From: Plant, Tom - Communities <Tom.Plant@Oxfordshire.gov.uk>
Sent: 22 March 2021 17:05
To: Matthew Chadwick
Cc: Transport CDC Minor; Planning; Cllr Arash Ali Fatemian
Subject: 20/03467/F - Land Adjoining And West Of Stonecroft House Clifton Road Deddington

Planning application:	20/03467/F
Location:	Land Adjoining and West Of Stonecroft House Clifton Road Deddington
Description:	Erection of 7 one and two storey age restricted dwellings for older people (60 years) with access, landscaping and associated infrastructure
Type:	Full Development
Case Officer:	Matthew Chadwick

FIGURE 2

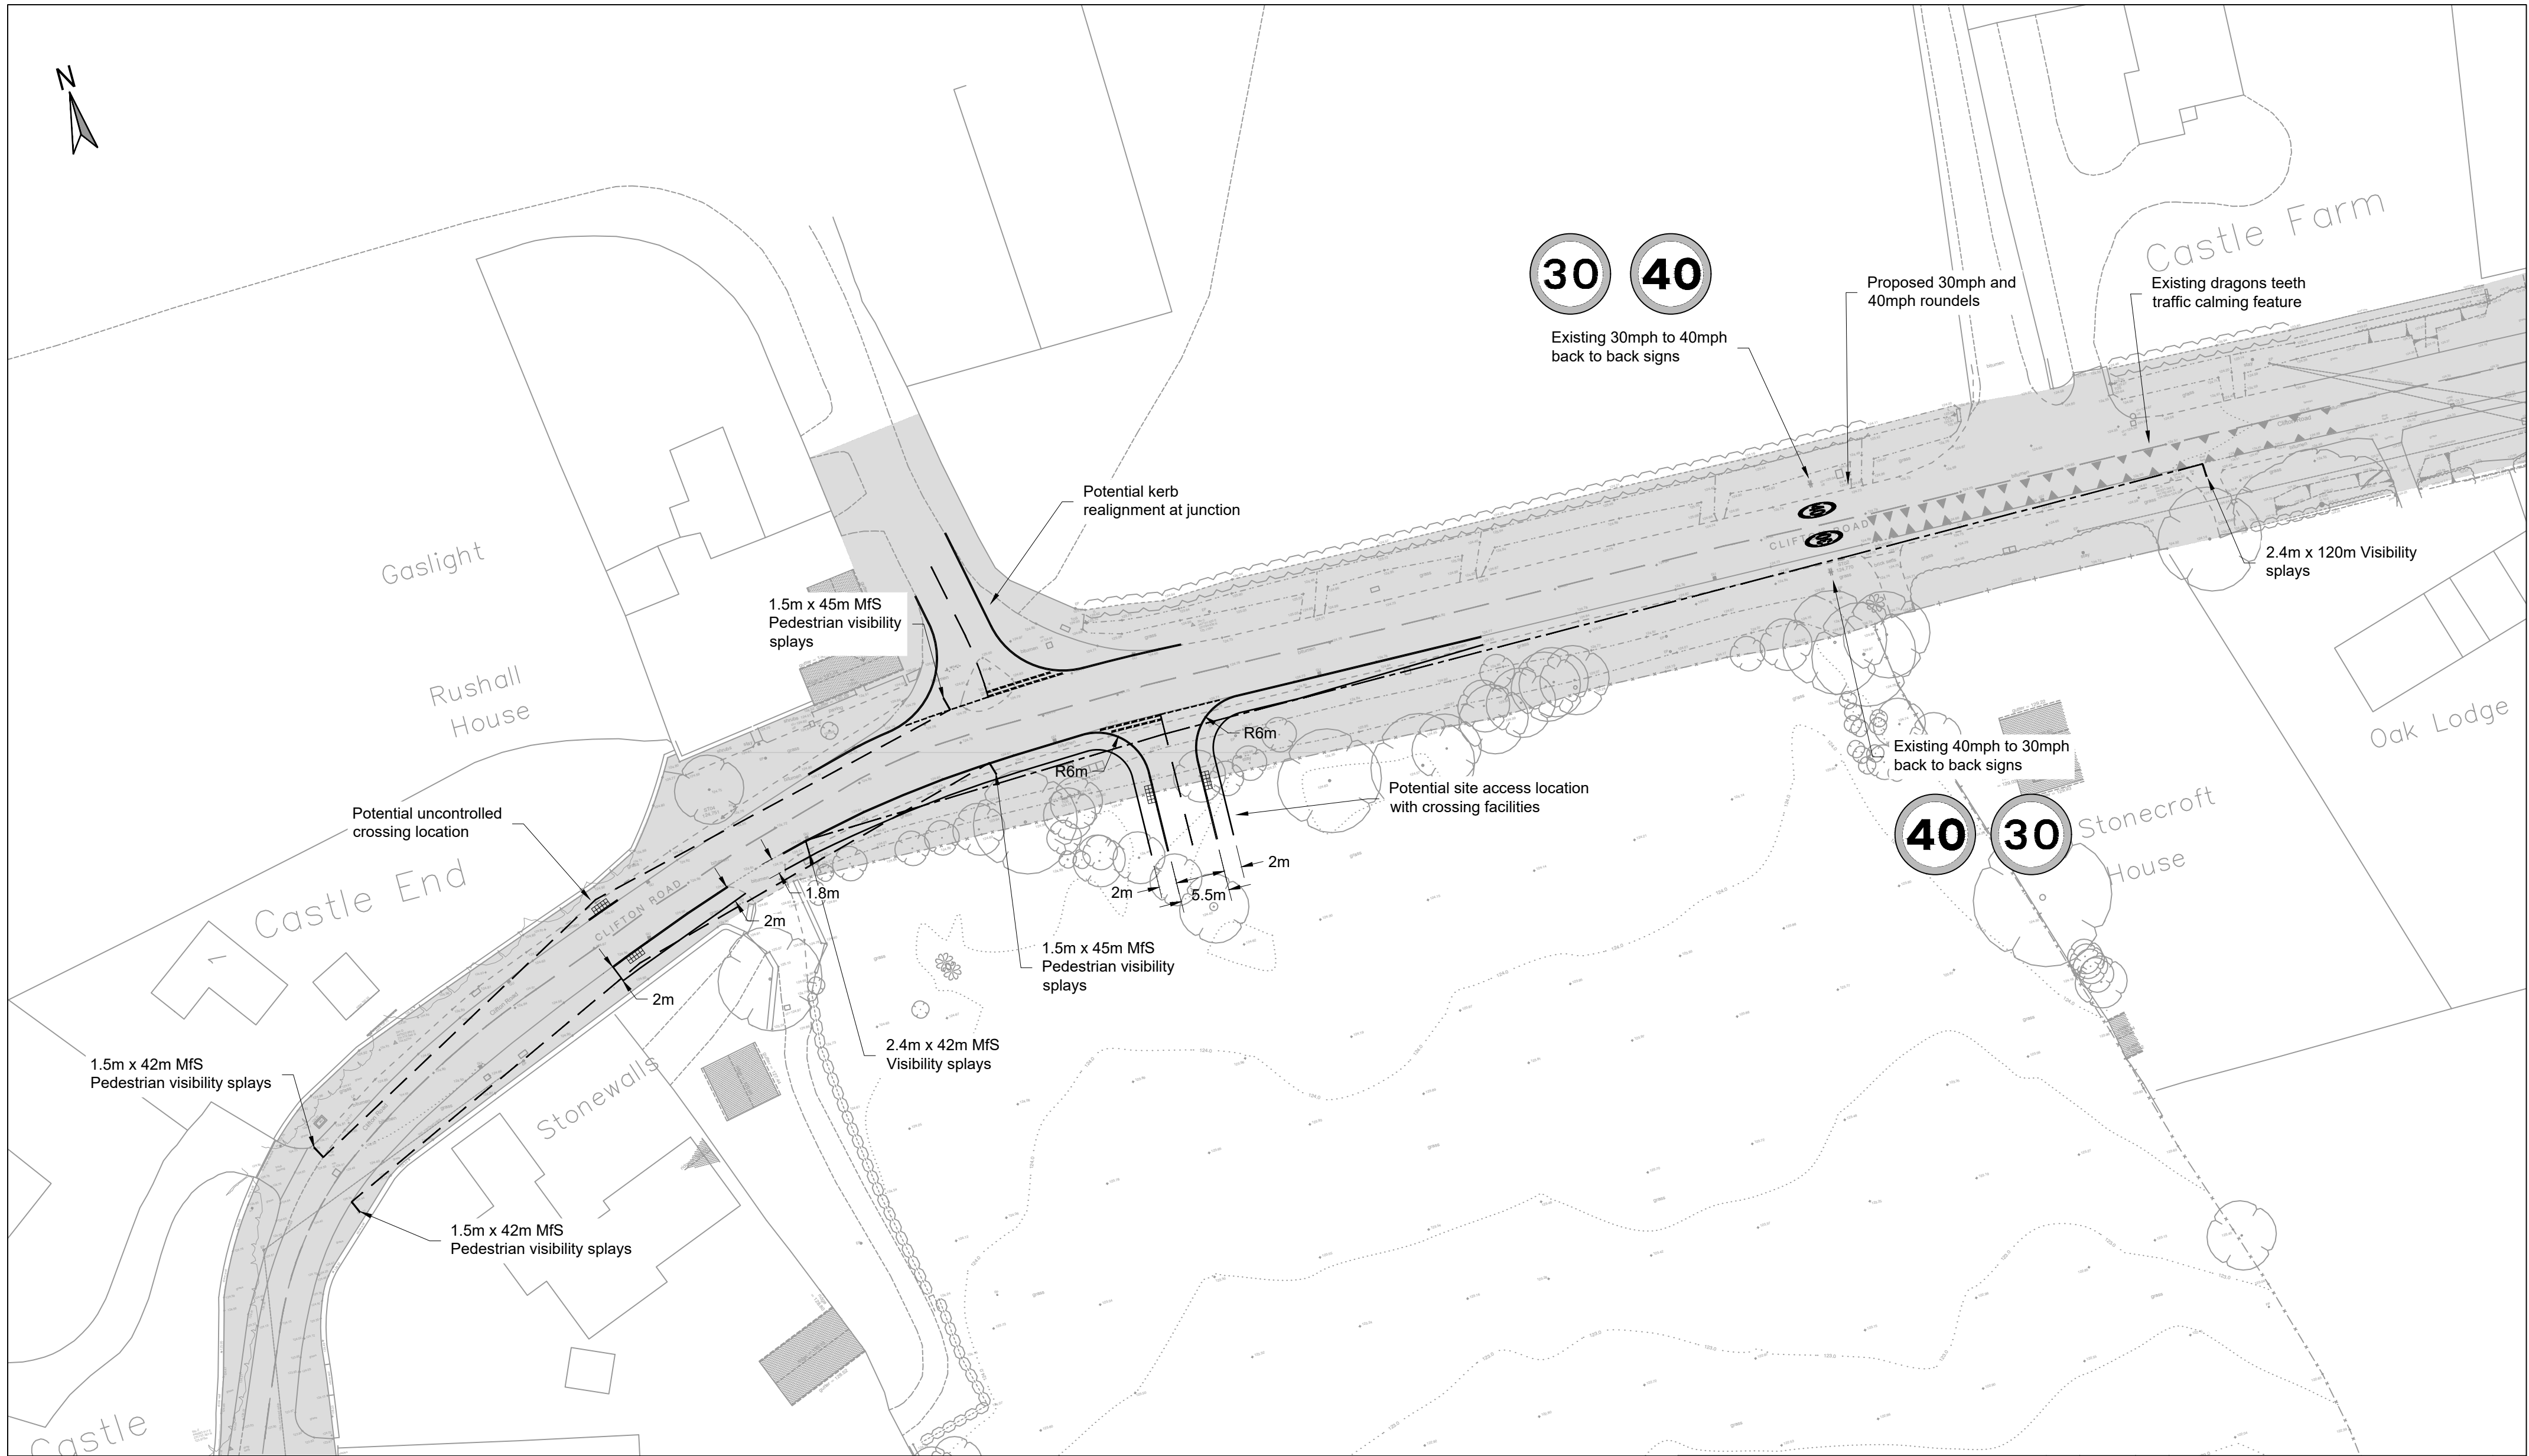
Oxfordshire County Council, as the Local Highways Authority, hereby notify the District Planning Authority that they **do not object** to the granting of planning permission, subject to conditions and a Section 106 Agreement securing the access works and offsite highway works that include the remodelling of the existing Earls Lane junction and provision of footway as indicatively shown on drawing P19-1601 Figure 2 Rev D.

The proposed site access is located directly opposite the existing Earls Lane junction with Clifton Road. Due to the conflicting nature of the proposed access and the existing Earls Lane junction, the applicant proposes to remodel the existing historic Earls Lane junction, and instead, create a simple priority junction, similar in design to that of the proposed site access. The two junctions will then be offset from the centreline of each other by approximately 16 meters.

It is noted by the LHA and the applicant that this short stagger distance is below the 50m minimum separation distance as set out at paragraph 2.23 of Design Manual for Roads and Bridges (DMRB) CD 123 (Geometric design of at-grade priority and signal-controlled junctions). However, DMRB standards are intended primarily for trunk roads, while Clifton Road is within a 30mph limit in a village setting and where the B4031 is a fairly lightly trafficked road. Taking this into account and the fact that there are many other examples of similar road layouts in village settings, it has therefore been deemed that a shorter stagger distance would be appropriate in this site context. Further, at the request of the LHA, the applicant submitted access drawings which included the proposed remodelled Earls Lane junction for a Stage 1 Road Safety Audit (RSA). Two options were submitted (option 1 and option 2 had alternative pedestrian crossing provision – see below for further details), and as a result of the RSA, the applicants transport consultant sought to address the items flagged, of which neither assessment flagged up the remodelled Earls Lane junction as an area of concern.

In addition to the advantages for the applicant by remodelling the existing Earls Lane junction, the proposed new geometry will allow vehicles on Earls Lane approaching the give way line to better assess approaching eastbound traffic on the B4031, and also reduce the speed at which this turn is made, this should therefore serve to improve safety for all road users too.

Pedestrian access is proposed via two two-metre footways either side of the five-metre access. The western footway tapers off a short distance into the site, whereas the eastern footway continues south into the site.

An informal pedestrian crossing has been proposed to the west of the site's access, so that a north south pedestrian crossing can be provided that links up with the existing footway provision found on the northern side of the B4031. This informal pedestrian crossing ensures that a safe and

The applicant has also proposed to provide a further footway provision east along the northern side of the B4031, and round past Rushall House, by using newly created highway verge, so that this development proposal can tie into the committed footway provision that will be delivered by planning application 19/00831/OUT, permitted at appeal in October 2020. This additional footway provision will also ensure that both the committed development of 15 dwellings located further east from this application site will provide a safe crossing point over the B4031, and a safe, continuous footway from Clifton Road along Earls Lane, onto the Deddington Health Centre, and Primary School. Finally, by providing the north south pedestrian crossing closer to Earls Lane, this crossing will likely be better used, than if it were located further west, as was indicated in option 1 of the two options submitted for Stage 1 RSA.

For the reasons as outlined above, and based upon the discussions between the LPA, LHA and the applicant during the life of this planning application, the LHA can conclude that the proposals are unlikely to result in any additional adverse impact upon the local highway network from a traffic, safety and convenience point of view, therefore I offer no objection, subject to conditions and a legal agreement to secure the access and off-site highway works as indicatively shown on Drawing P19-1601 Figure 2 Rev D.
